WEST SUSSEX COUNTY COUNCIL CONSULTATION

TO:	Arun District Council FAO: Anita Gardner
FROM:	WSCC - Highways Authority
DATE:	12 May 2022
LOCATION:	Little Orchard 2 Sea Lane Middleton on Sea PO22 7RL
SUBJECT:	M/42/22/PL Demolition and erection of 1 No dwelling. This site is in CIL Zone 4 and is CIL Liable as new dwelling.
DATE OF SITE VISIT:	n/a
RECOMMENDATION:	Advice
S106 CONTRIBUTION TOTAL:	n/a

PROPOSED SITE PLAN

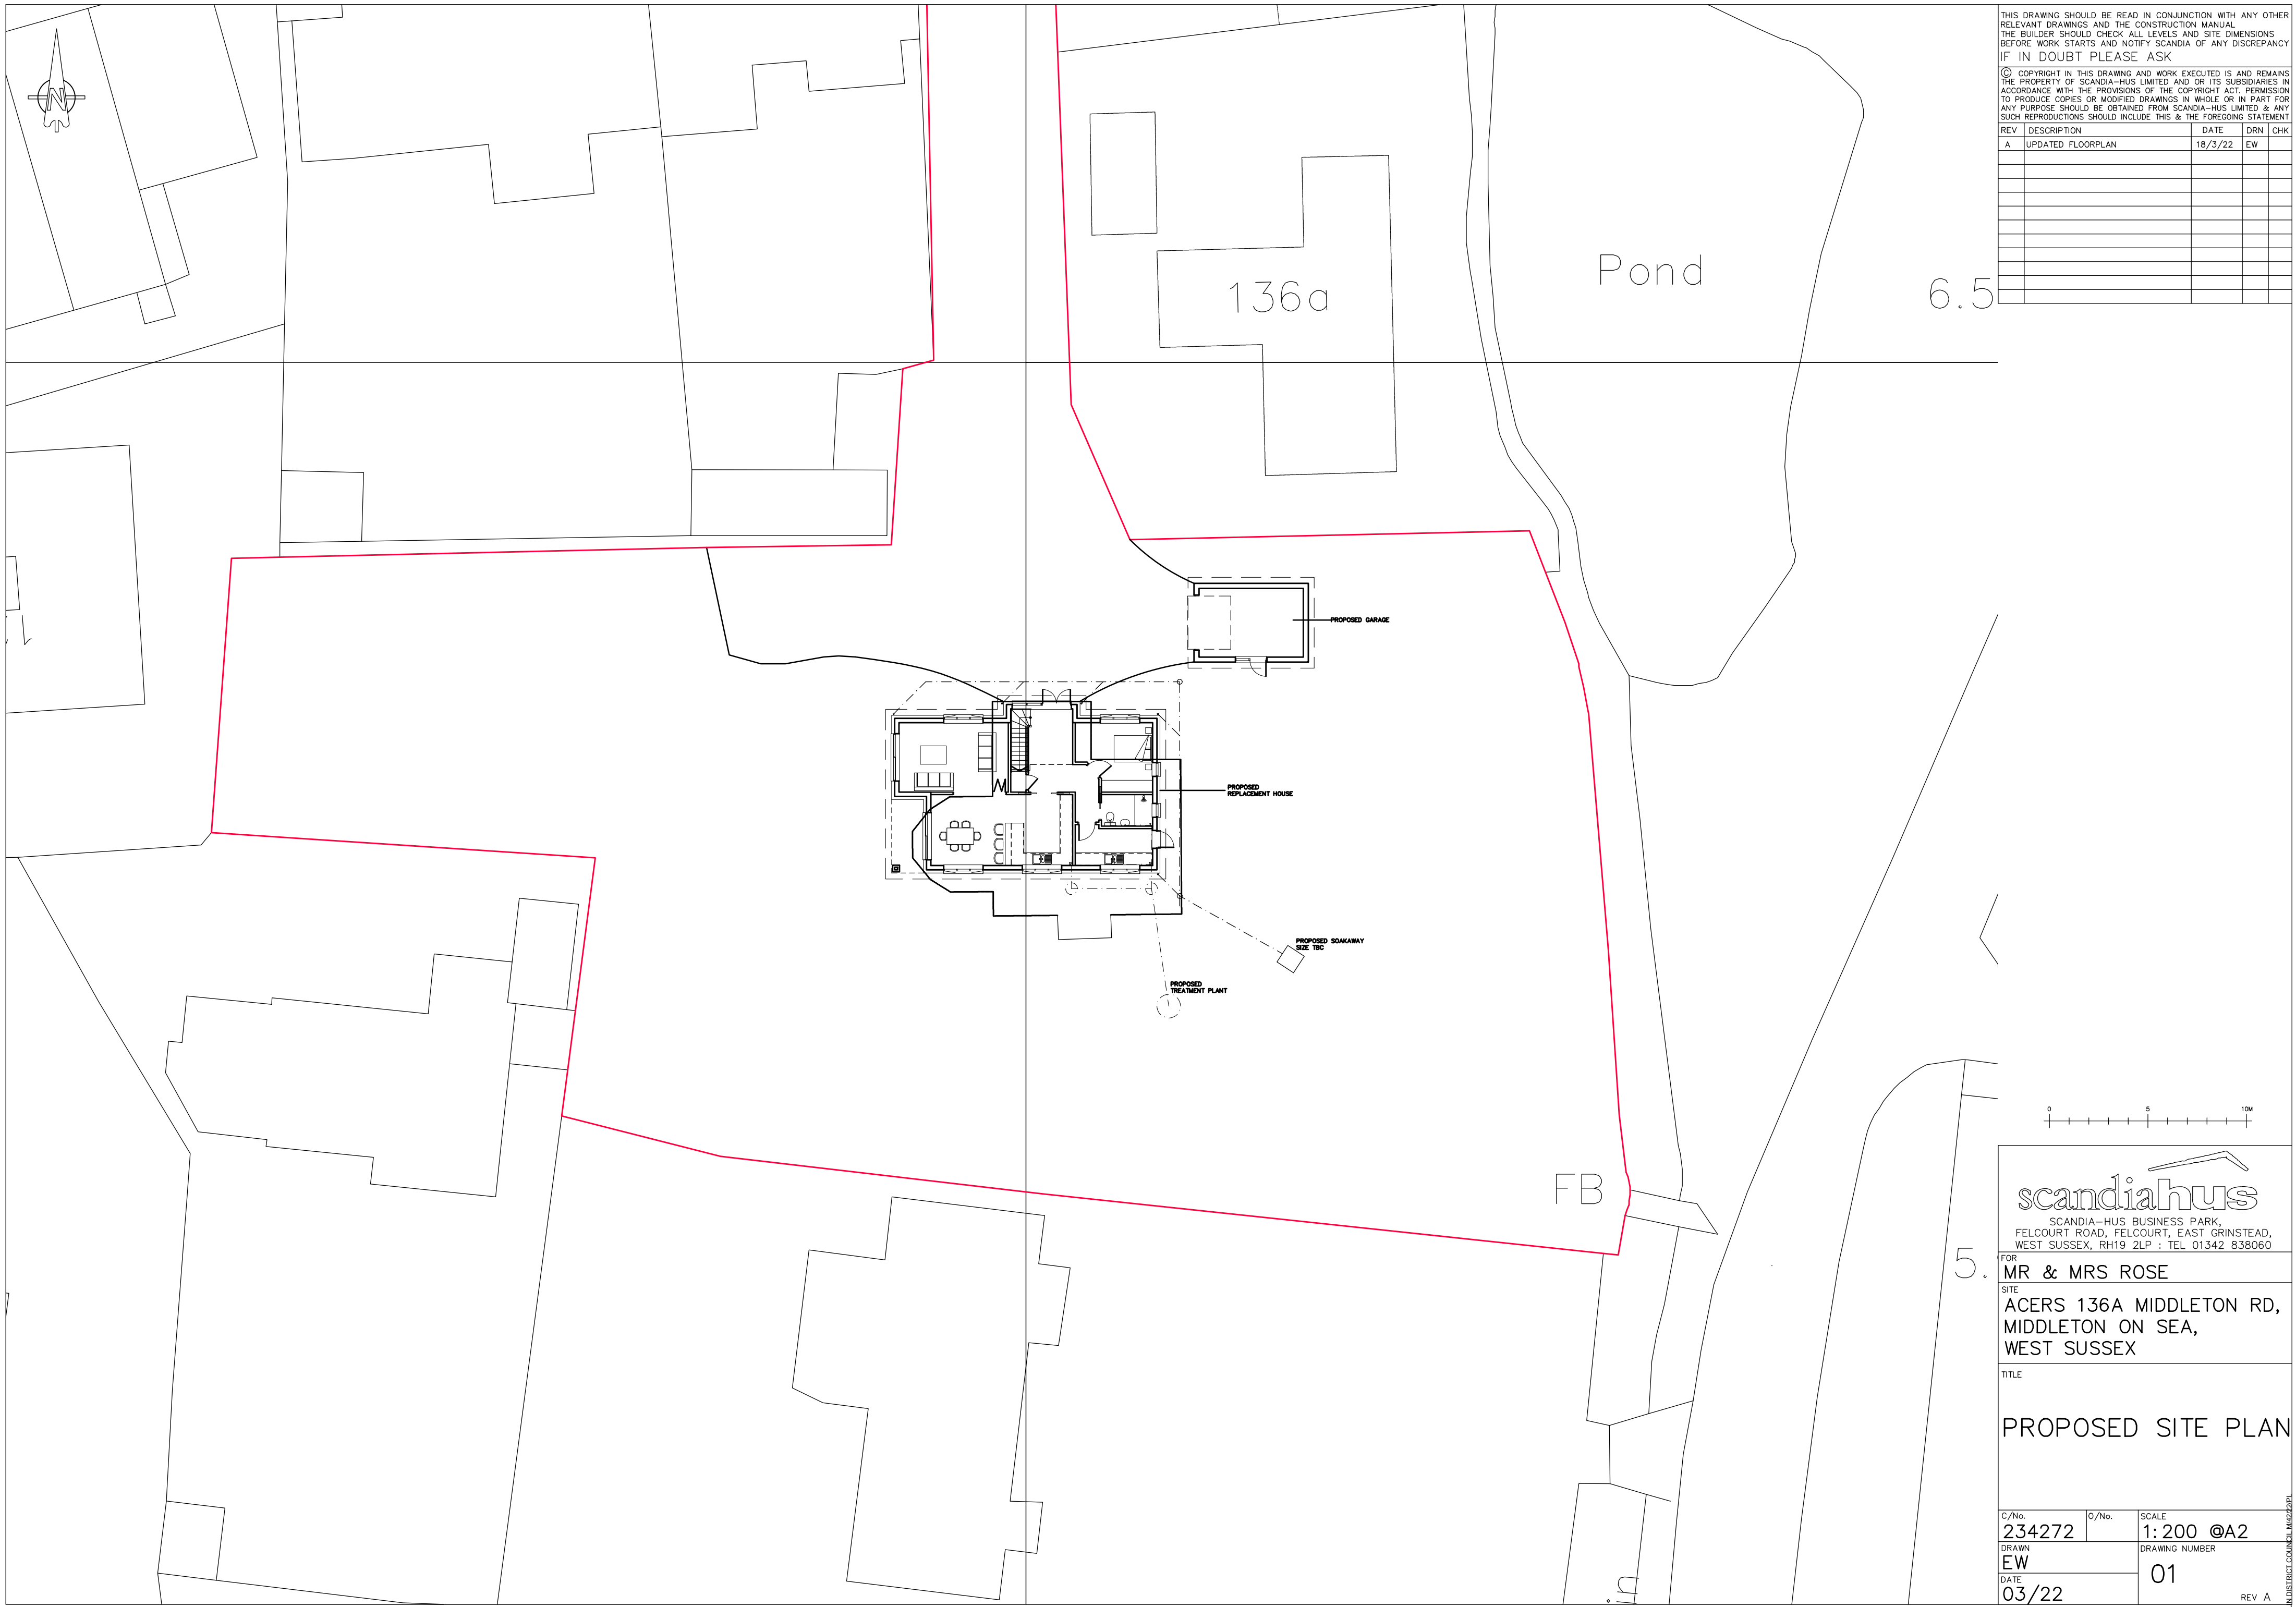
The applicant has provided a lard hardstand to accommodate the parking requirements of the development.

The applicant is asked to make sure the garage dimensions meet Arun Parking Standards.
